West Burton Solar Project

Change Application and Consultation Report

Prepared by: Lanpro Services
January 2024

PINS reference: EN010132
Document reference: CR1/WB9.2

West Burton 1
Access Road

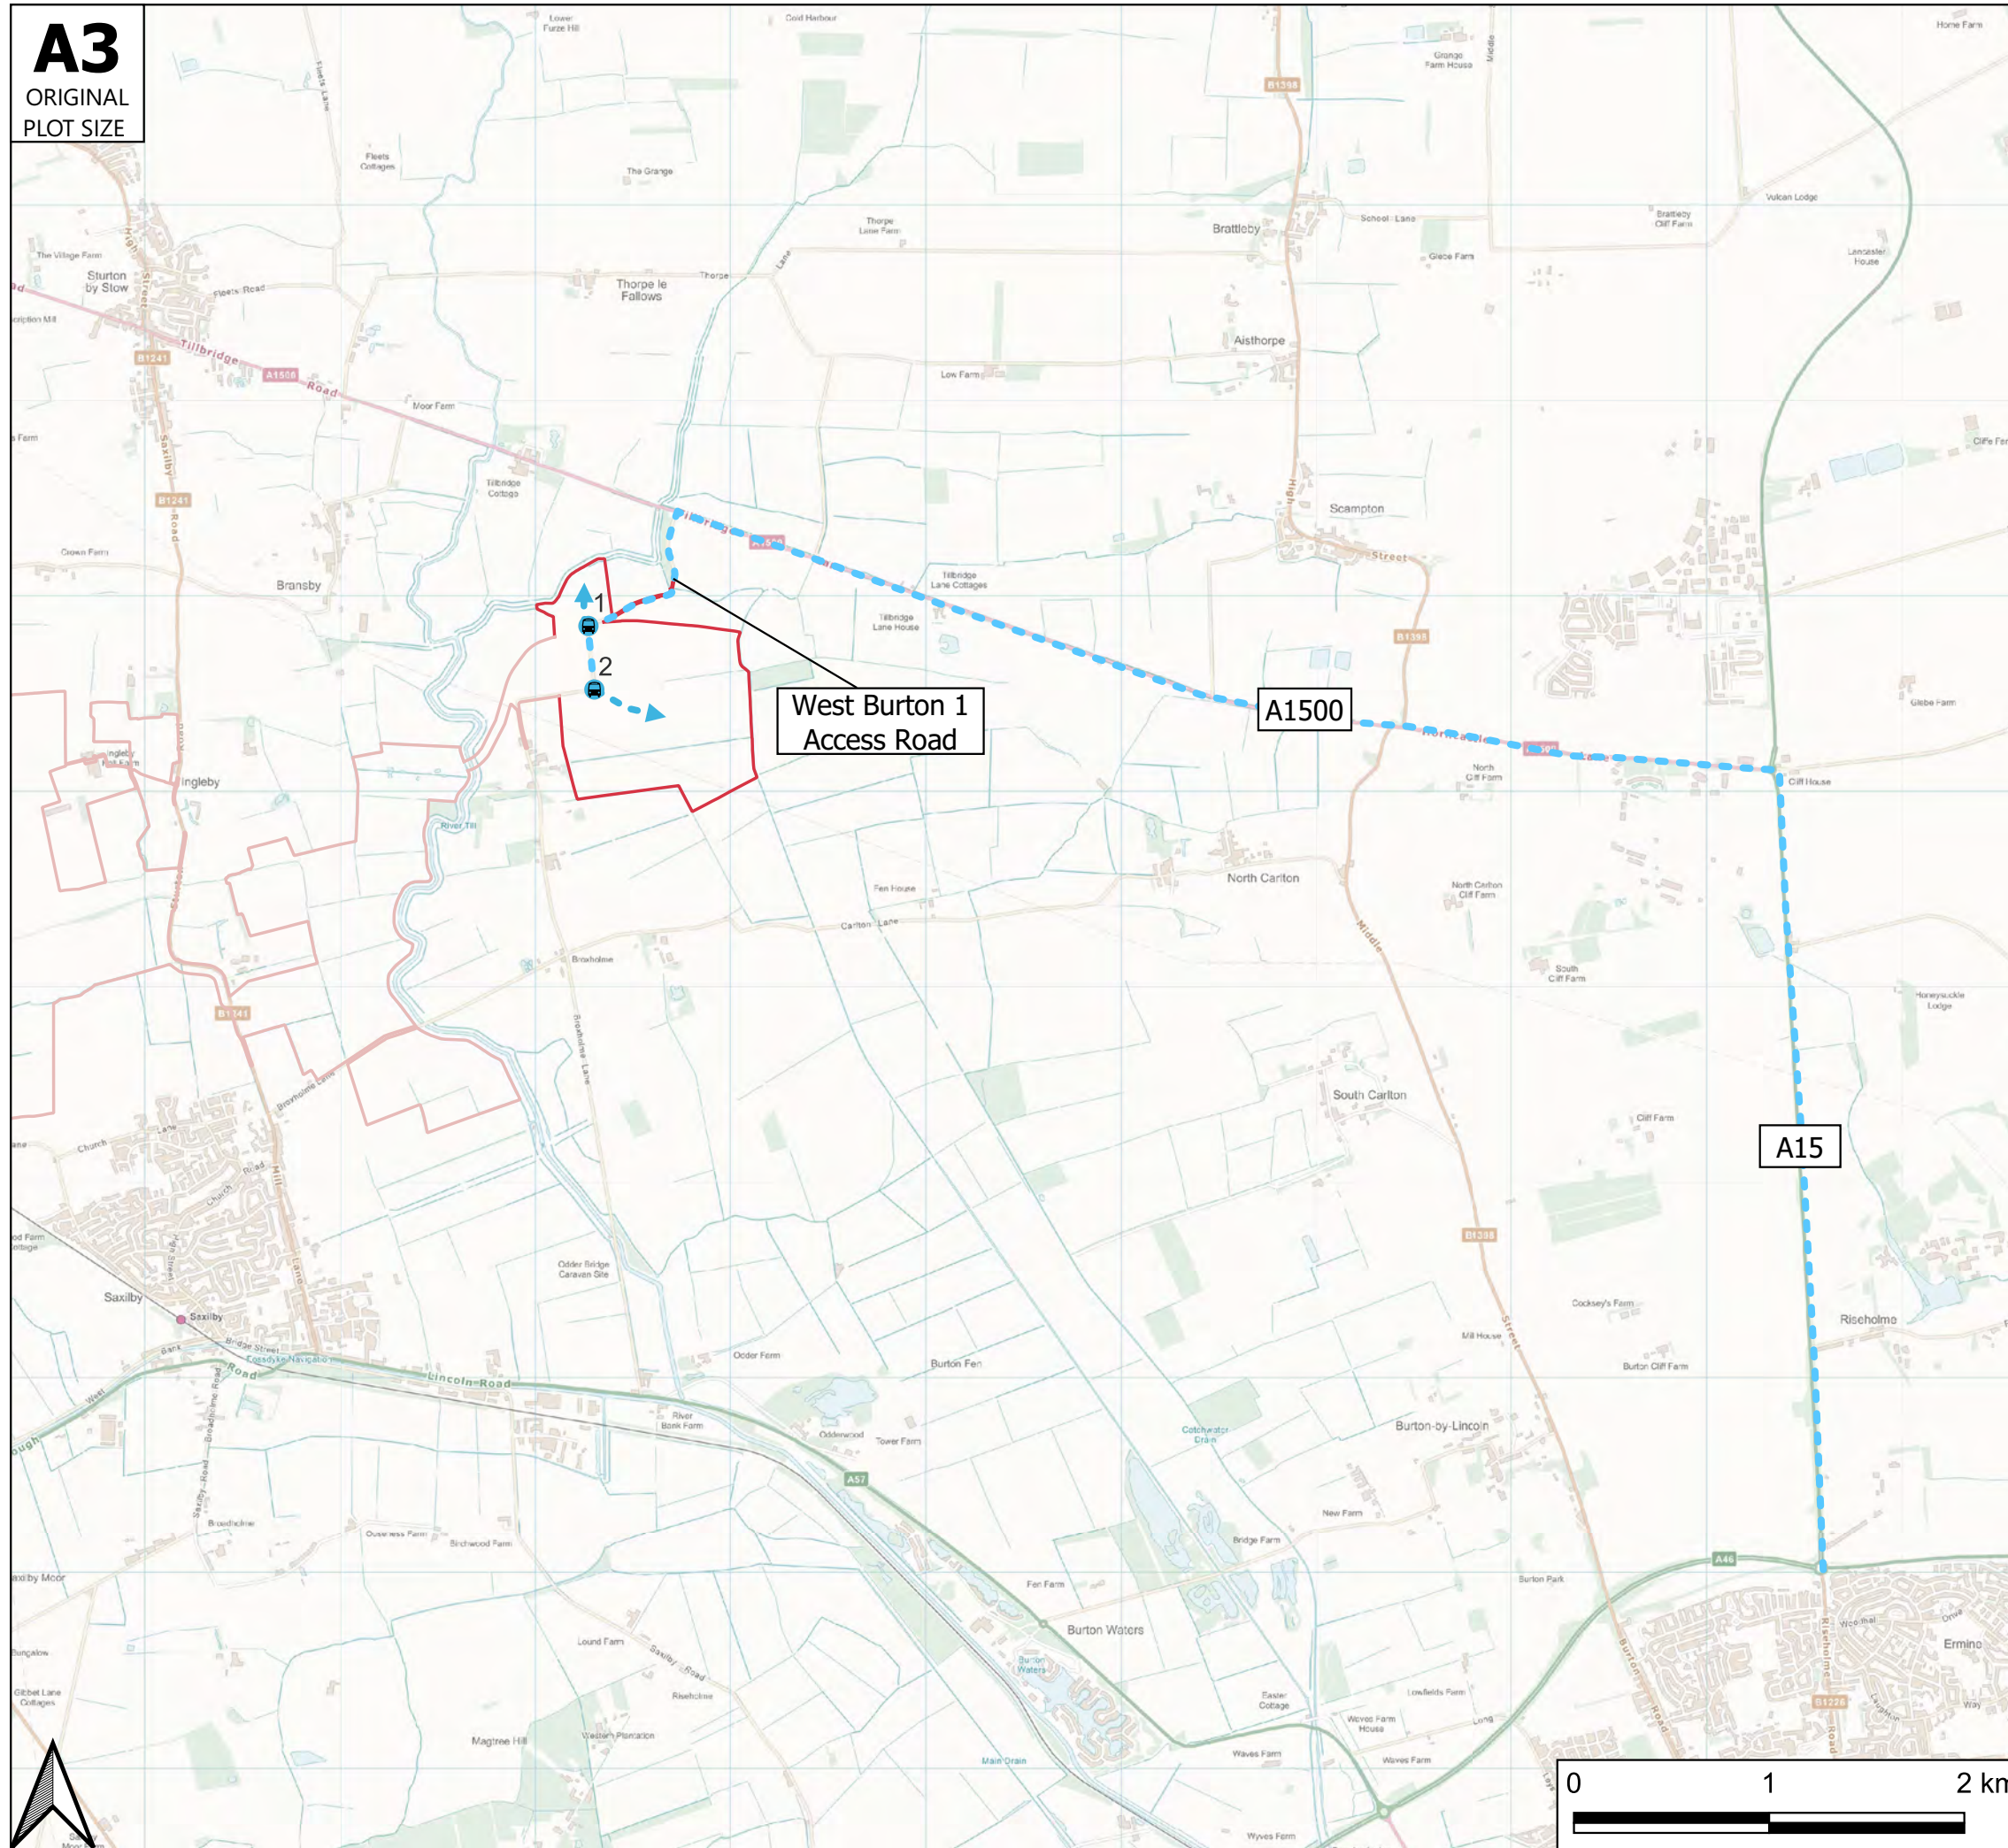
- 3.2.1 Change 1 comprises an extension to the Order Limits along the highway from the West Burton 1 Site to the A1500 Tillbridge Lane, to the north of Broxholme. This section of highway is a narrow single-track road with restricted visibility in some locations. Discussions between the Applicant and Lincolnshire County Council Highways have indicated that the creation of temporary passing places within the highway boundaries during the construction phase might be required, subject to detailed design following the grant of the DCO. In order to provide the applicable highway powers in the DCO to construct any required passing places it is therefore necessary to include this section of public highway within the Order Limits.

"LCC-04: However, concern is raised regarding the access route proposed for West Burton 1. This is proposed to use around 1.2km of the unclassified road south of A1500 (Figure 6.1 of TA). The number of daily vehicles using this, associated with the development, would be five HGVs and 23 cars. This is in addition to the surveyed flows of around 200 existing daily vehicles on this route. This road is a single track road around 3m in width, passing cars need to use the verge and for cars passing HGVs it is problematic. The road is also not straight with several sharp bends over this short length."

"LCC-05: Section 7 of the Transport Assessment (TA) proposes this same route for abnormal loads, with vehicles of 100 tonnes and 36m in length using this route. The TA suggest in Para 8.6 that temporary pass-by bays will be created on narrower sections of the highway and the DCO would allow powers to make adjustments in the highway verge."

"LCC-06: Recommend that for construction traffic, the applicant needs at this stage to identify where passing bays will be located on this route, there should be at least one bay on each straight section of the route, making around three bays over the 1.2km section. The proposed access points (Access 1 and 2) are to be at existing field accesses which are located on the bends. Layouts of the access junctions need preparing with swept paths for HGVs to show that two way movements can occur and the extent of the junction improvements necessary. "

- 4.7.6 TPA prepared a technical note to address the above points (along with others that were raised in the Relevant Representation **[RR-188]**) which proposes passing places on either side of the unnamed road. The proposals have been prepared in conjunction with the project landscape and ecological consultants. This was sent back to the highway officer on the 4th October 2023 and they responded on the 8th October to confirm they were content with the proposed passing places.
